## Application for a Non-Material Amendment Following a Grant of Planning Permission

Demolition of existing rear projection and construction of a single storey rear extension with a flat roof, 3 panel sliding door and 3 roof lights with other associated alterations.

22/1383/HD

1448-31

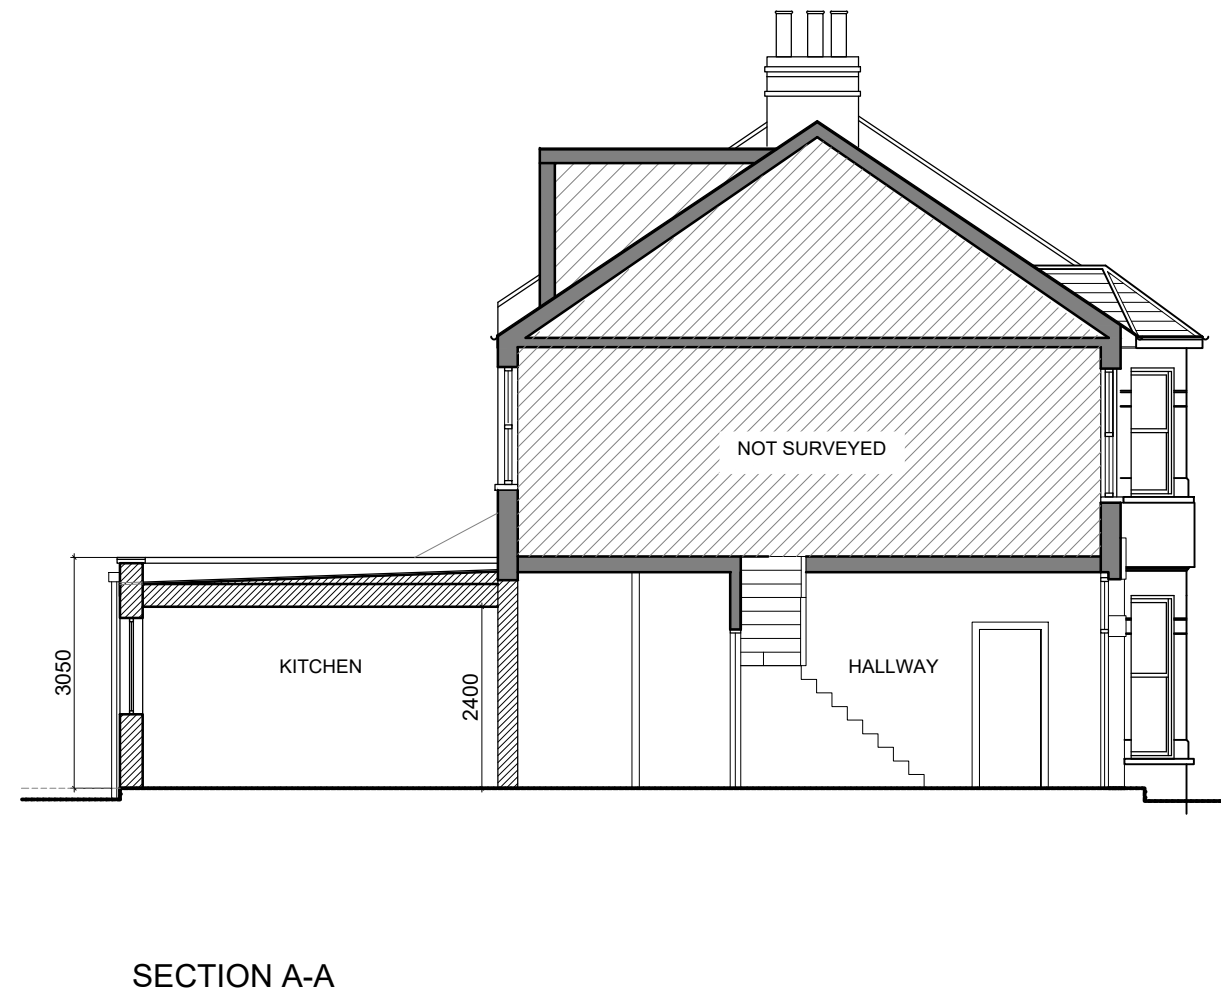
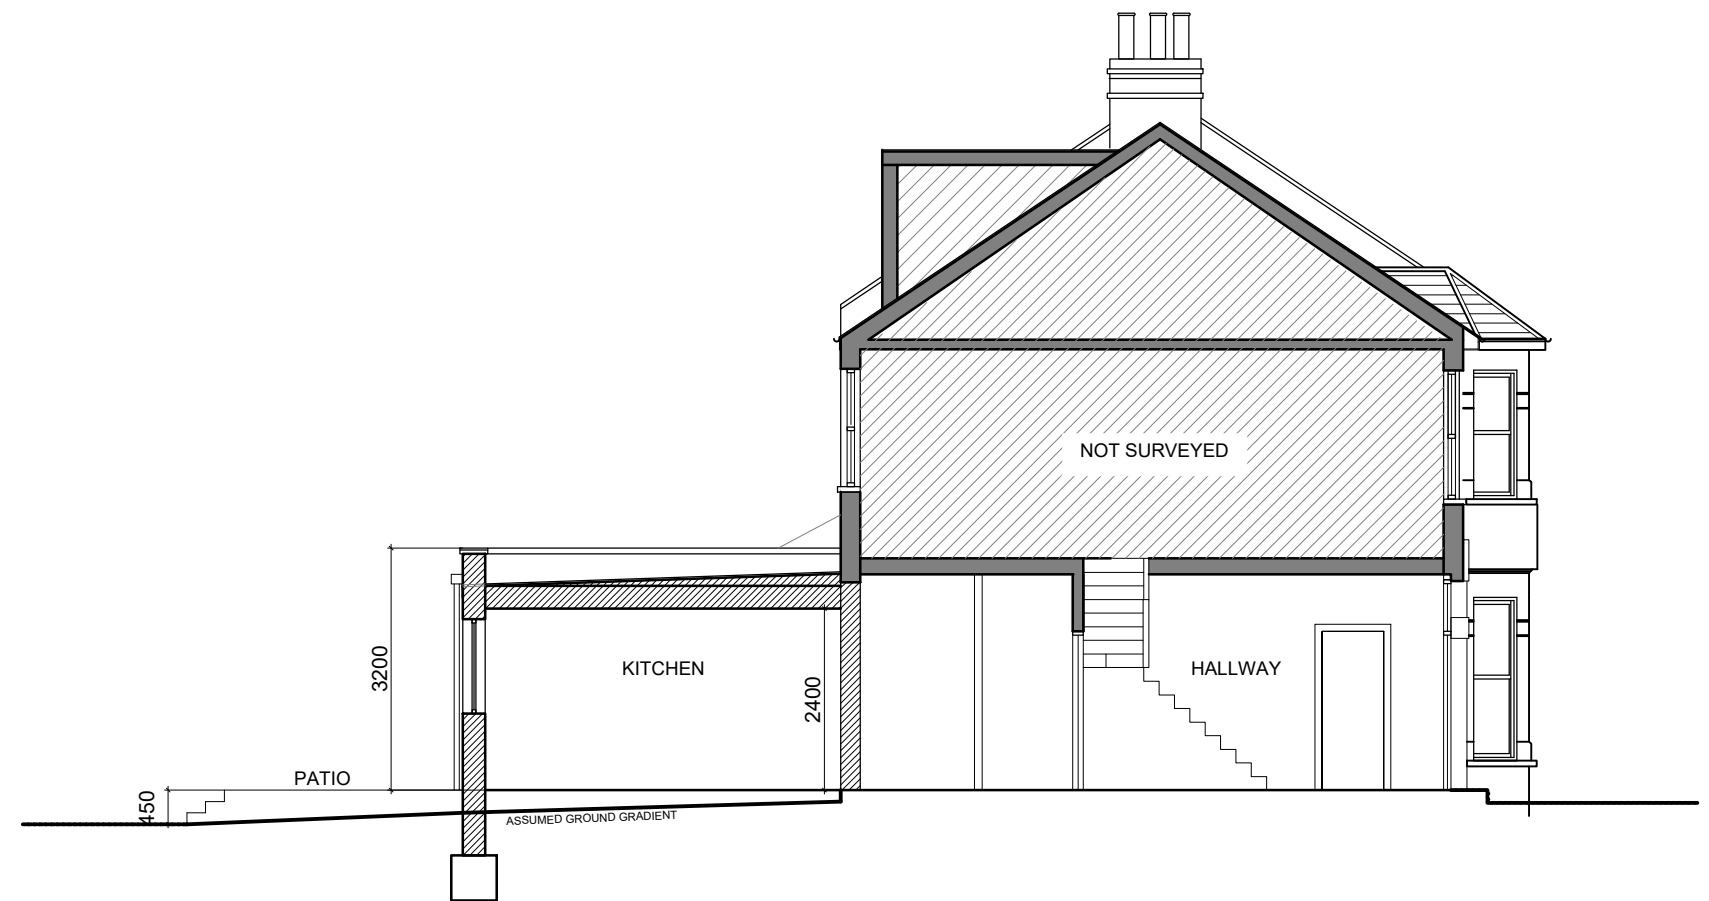
1. Increased in height: The height of the rear extension is increased by 150mm which is just a 5% increase to the approved height.
2. A raised patio is added to the rear.

After the original Planning consent and Building Regulations submission, it was necessary to increase the thermal insulation to comply with the latest Building Regulations. This increased the roof thickness and in order to retain the internal floor to ceiling height and correct flashing detail the parapet upstand could not be reduced, so overall the height of the rear extension is accordingly increased in height by 150mm to the approved plans.

Dwg. No.  
**1448-30**

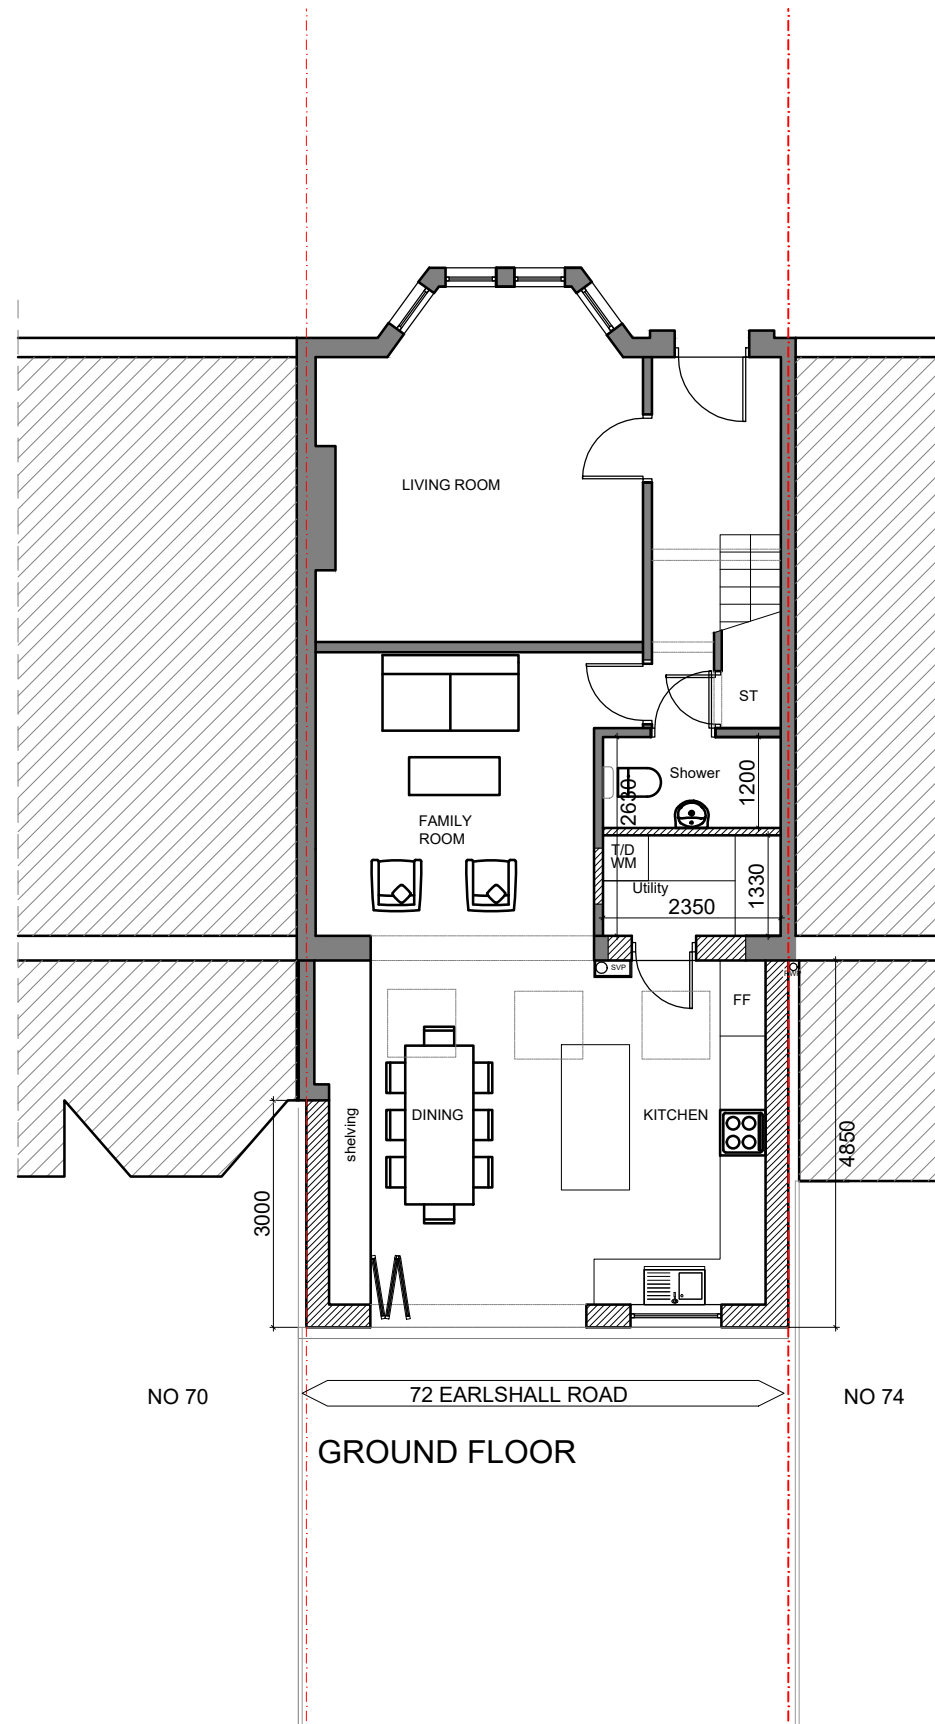
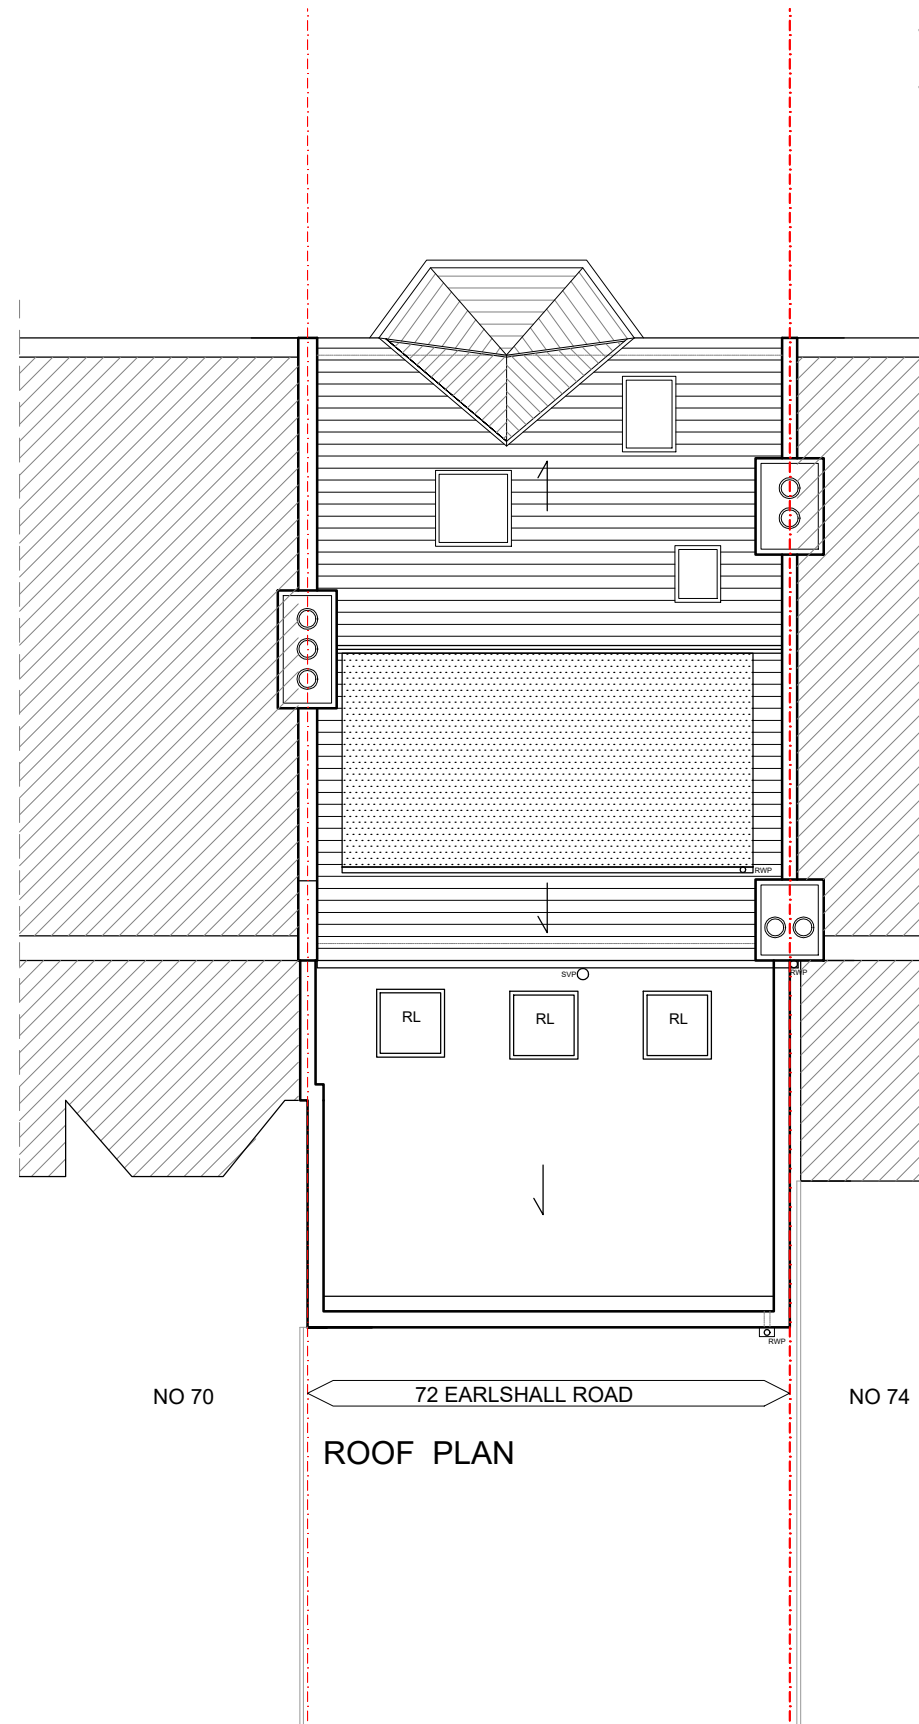
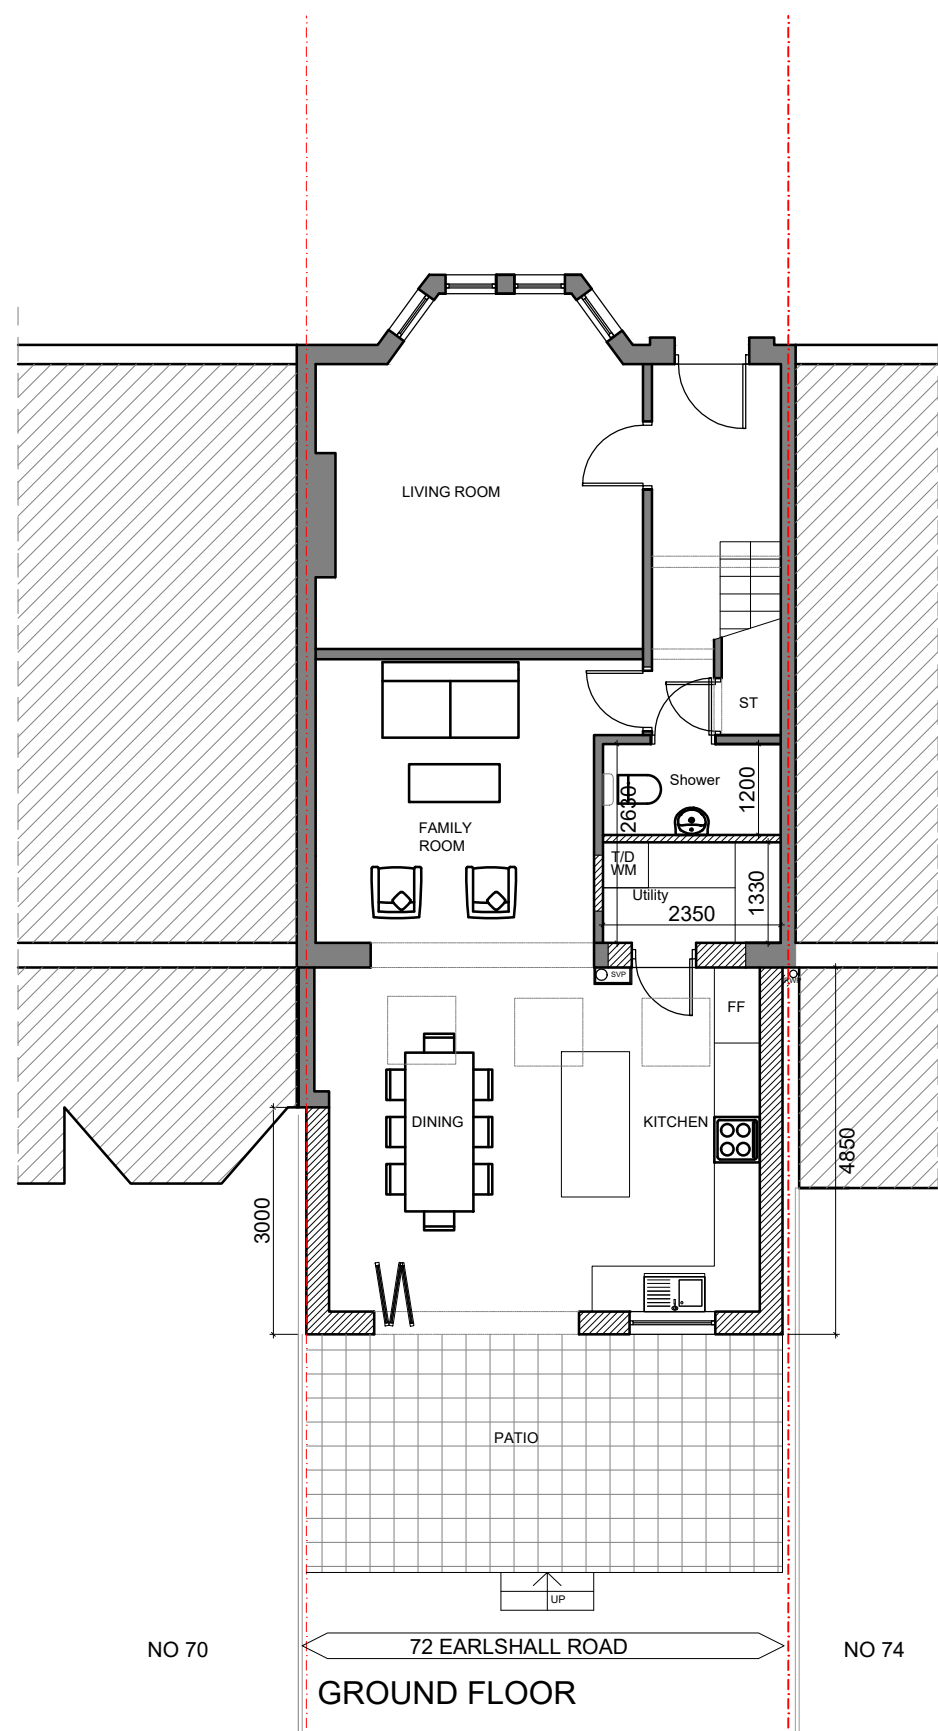
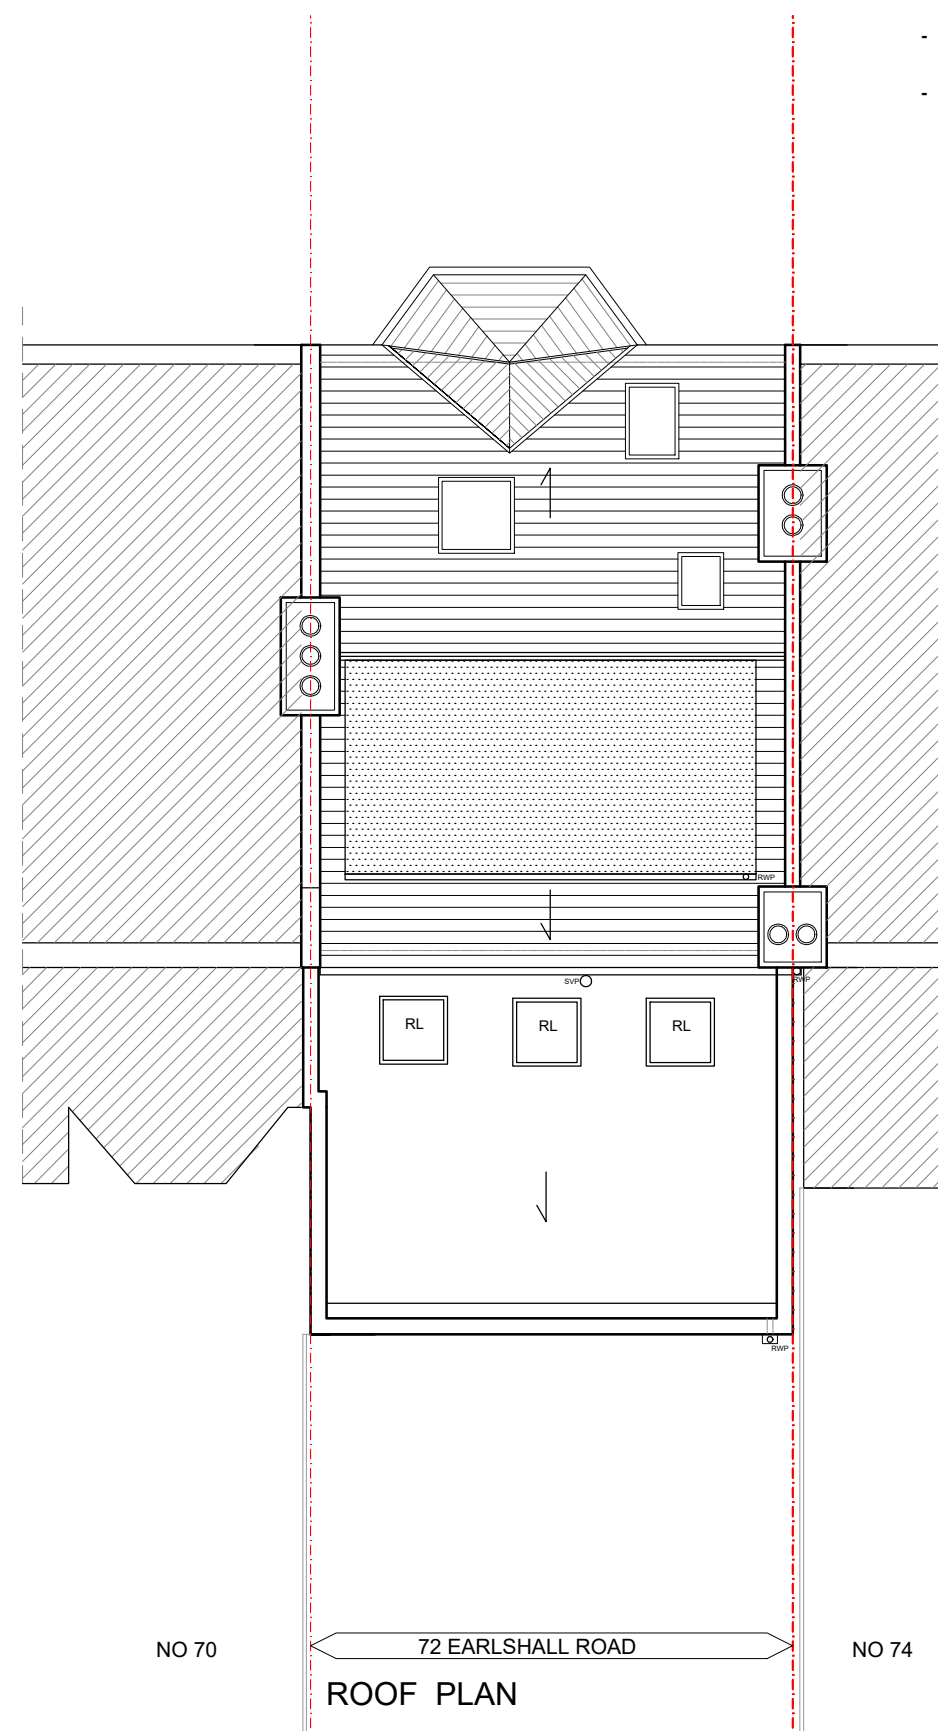
On the original Planning drawing, no new patio was shown as there was an extensive existing patio, and it had not been anticipated that the patio would exceed 0.3m in height, above ground level, and as such consent was not required. At Building Regulations stage, a patio of 2m depth was added and this was shown with a step down of 150mm from finished ground floor level, which did not require planning consent. When on site it was decided to retain the patio at ground floor finish level to improve access generally. In addition, it was decided to extend the depth of the patio to 3m. None of this in itself requires planning consent, however the ground falls away from the rear of the house, and as a result at the furthest extent of the patio there is lower level. This difference was further increased as the area directly in front of the patio has been levelled out a little directly in front of the patio. Overall this gives a step down of approx. 450mm, which is just 150mm above that allowed under permitted development.
